RE: **Lot 9 Block 10 Volcano Cliffs Unit 22 SAD 228**  
**6400 Petirrojo NW**  
**Grading and Drainage Plan**  
**Engineers Stamp Date 12/7/17 (D10D003F9)**

Based upon the information provided in your submittal received 12/7/17, this plan is approved for **Grading Permit**.

RE: **Lot 9 Block 10 Volcano SAD 228**  
**6400 Petirrojo NW**  
**Volcano Cliffs Subdivision**  
**Grading and Drainage Plan**  
**Engineers Stamp Date 12/4/17 (D10D003F9)**

Based upon the information provided in your submittal received 12/4/17, this plan cannot be approved for Grading Permit until the following comments are addressed.

ENGINEER'S SEAL 12/7/17 12/4/17 DAVID SOULE P.E. #14522	6400 PETIRROJO NW	DRAWN BY WCWJ DATE 12-01-17 21827-LAYOUT-12-01-17
	GRADING AND DRAINAGE PLAN Rio Grande Engineering 1806 CENTRAL AVENUE SE SUITE 201 ALBUQUERQUE, NM 87106 (505) 872-0899	SHEET # — JOB # 21827

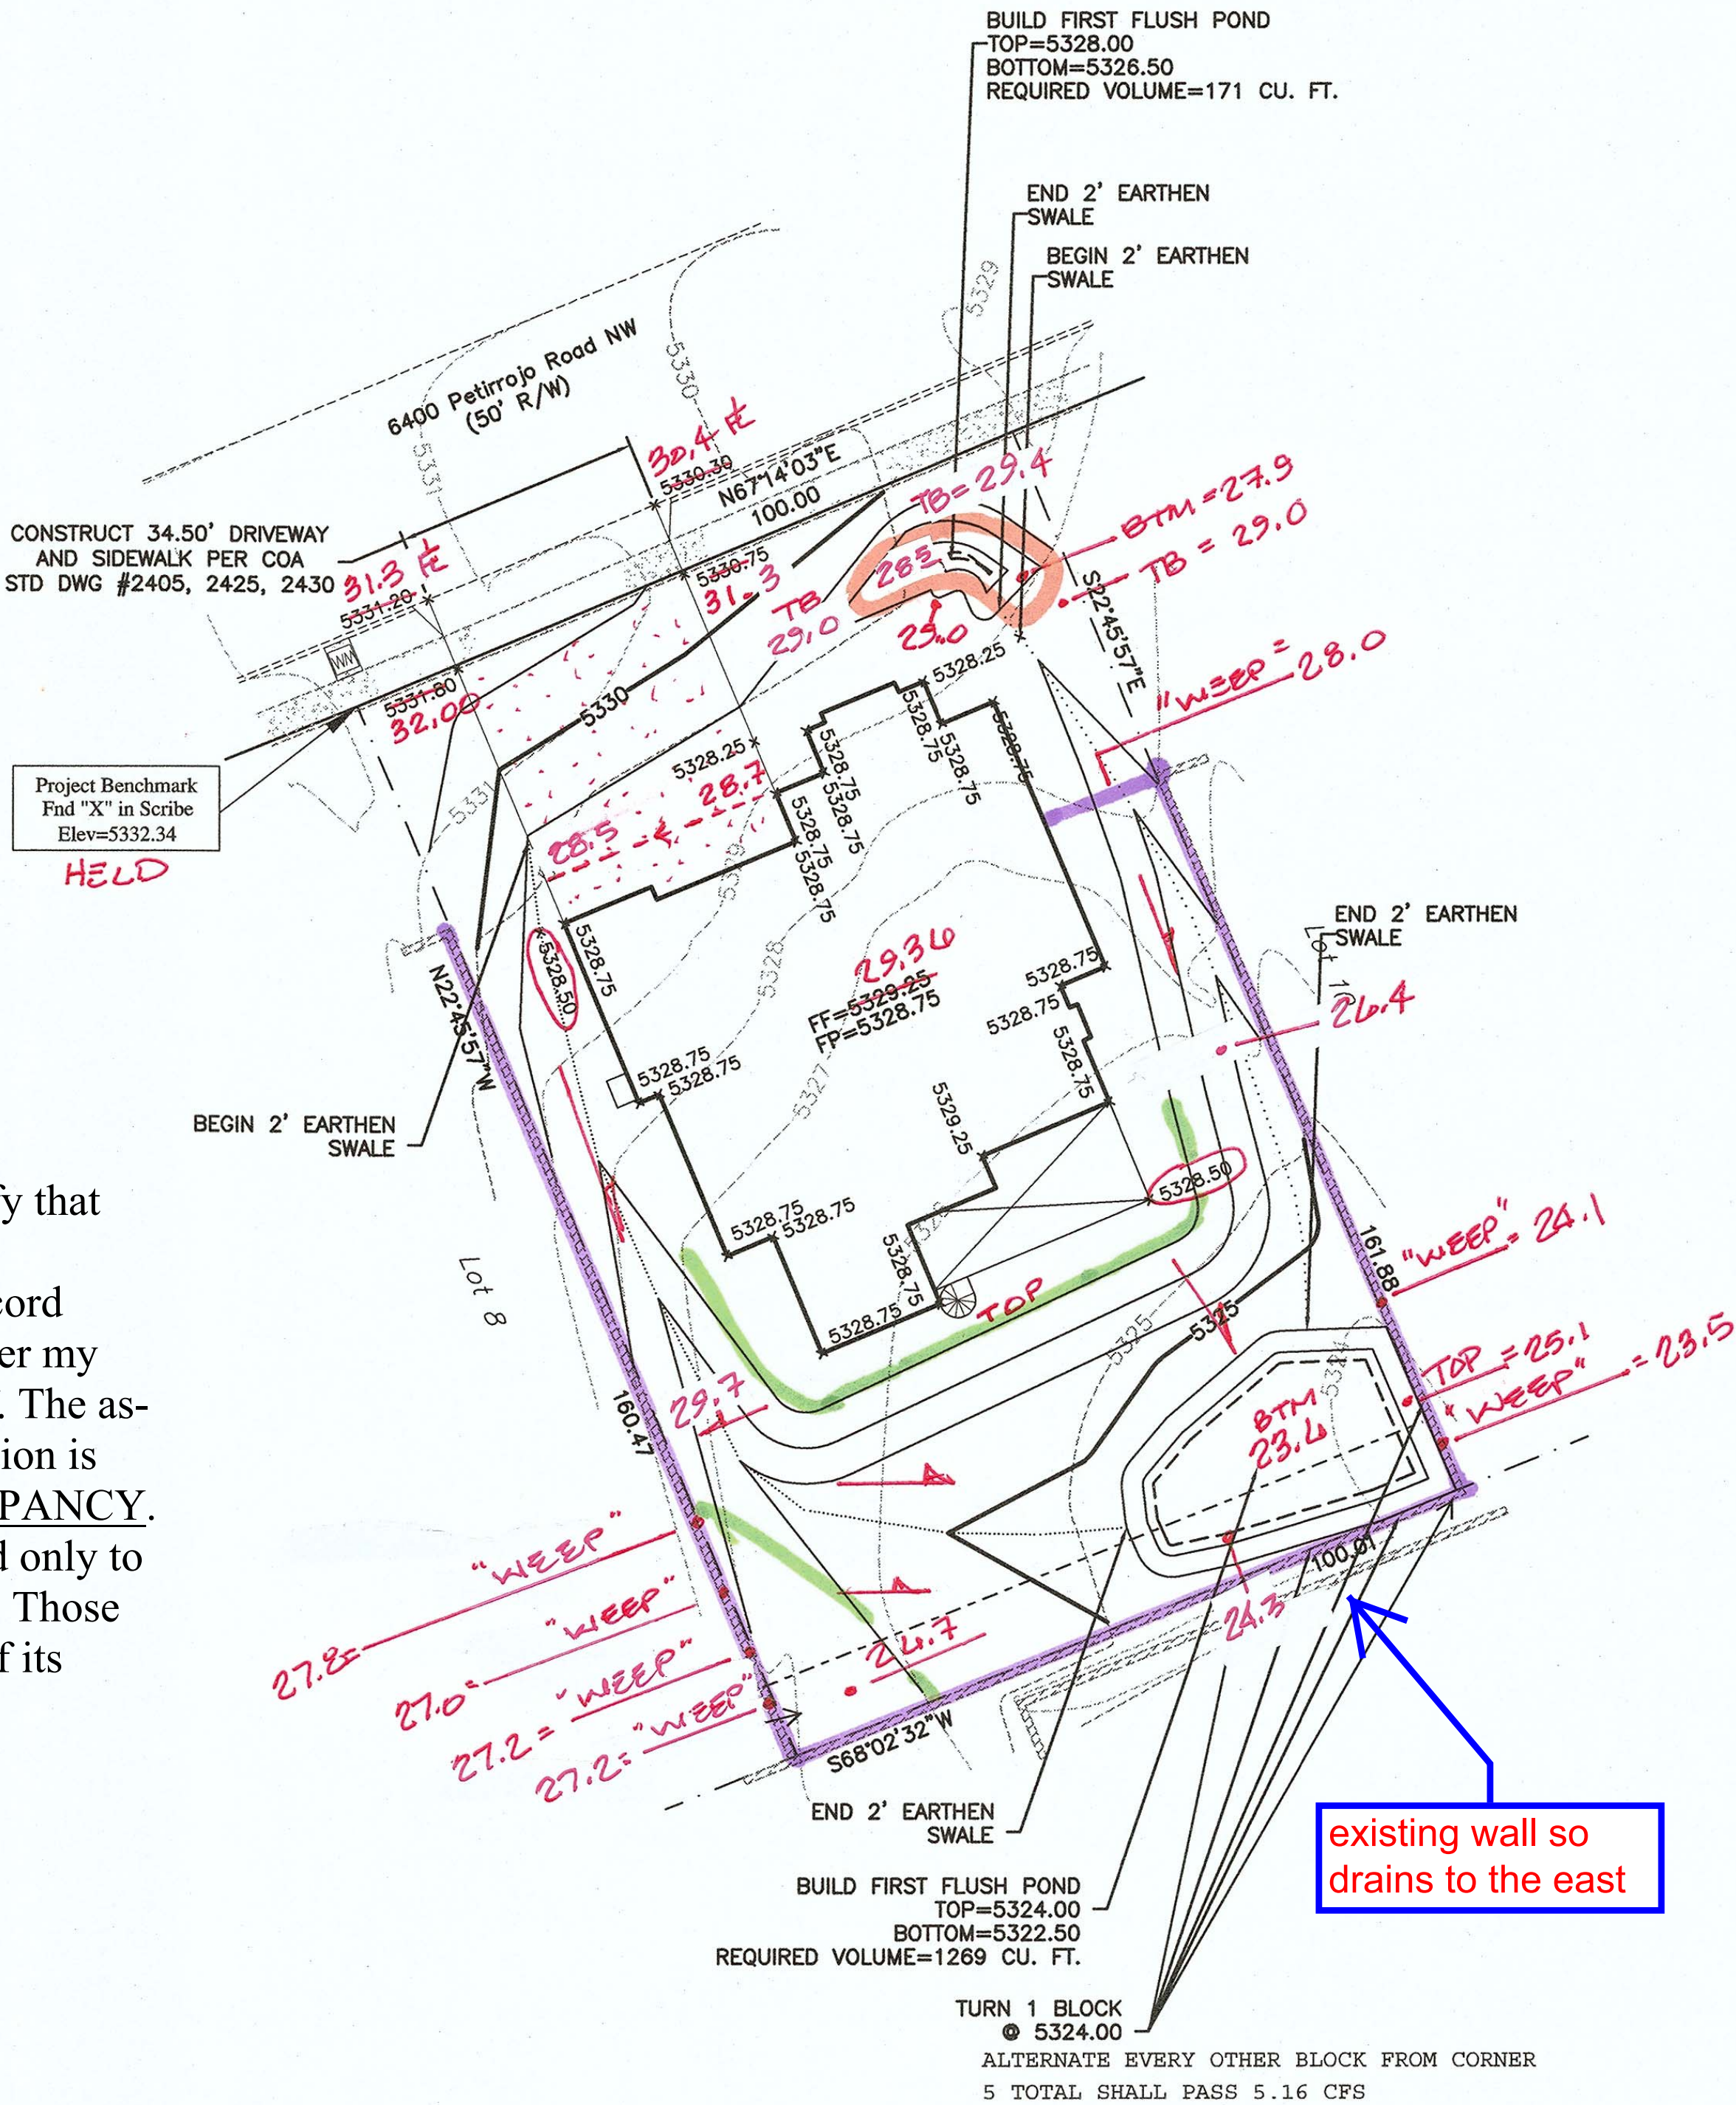
- Show the 10' PUE in the rear yard. **ADDED**
- Provide the upstream flows entering the site. **ADDED**
- The openings in the garden wall should be placed in the SE corner of the east wall. Provide the flows exiting this area. **ADDED**
